Subject: Submission on Sydney Metro West Environmental Impact Statement 3
Target Date: 14/07/2022
Notes:
File <FOLDERNUMBER> D08503630
Reference:

- (a) **That** Council approve the submission at Attachment 1 to the Department of Planning and Environment (DPE) on the Environmental Impact Statement 3 for Sydney Metro West, noting Council's support for the Sydney Metro West project and the following key components of the submission:

Figure 3 | Proposed modification to the Rosehill dive structure (Source: Sydney Metro)

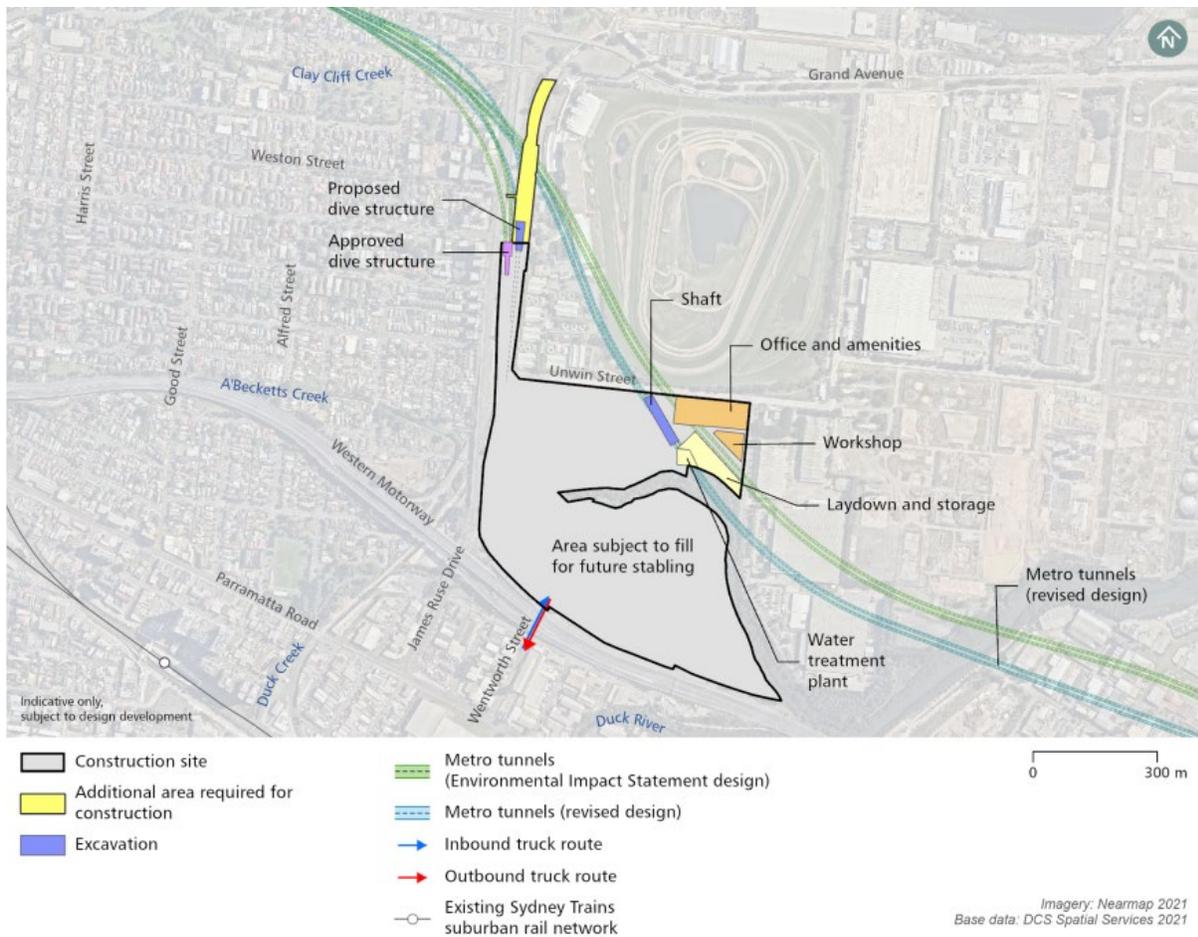
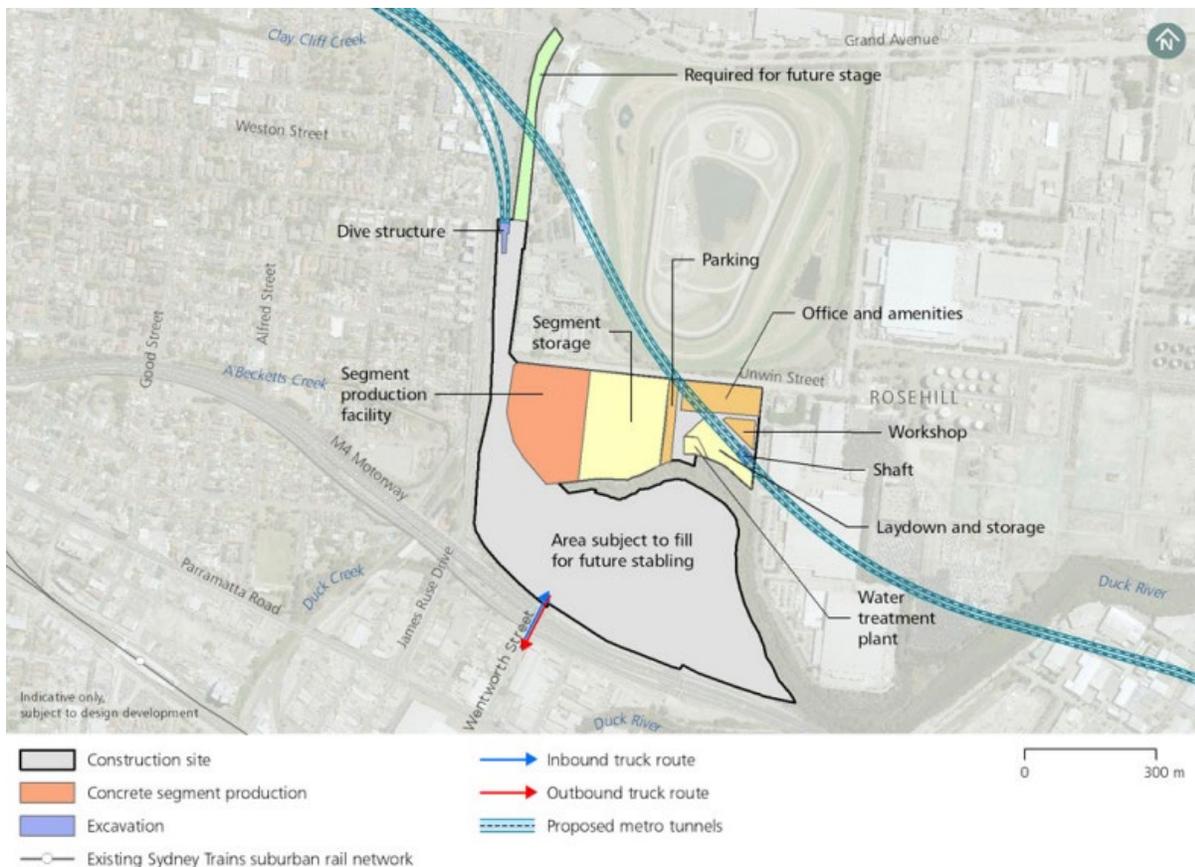
- ii. A'Becketts and Duck Creek Riparian Corridors should meet the minimum 30m (Duck Creek) and 20m (A'Becketts Creek) vegetated riparian zones as per NSW Department of Industry Guidelines for controlled activities on waterfront land - Riparian Corridors (2018);

- iv. The indicative layout plan for the CSMF should be updated to reflect the full scope of active transport connections consistent with the draft Camellia-Rosehill Place Strategy, specifically the active transport route along Duck Creek connecting the precinct to the M4 cycleway and connections from the recreation offset land to Duck Creek and Sydney Metro staff facilities;
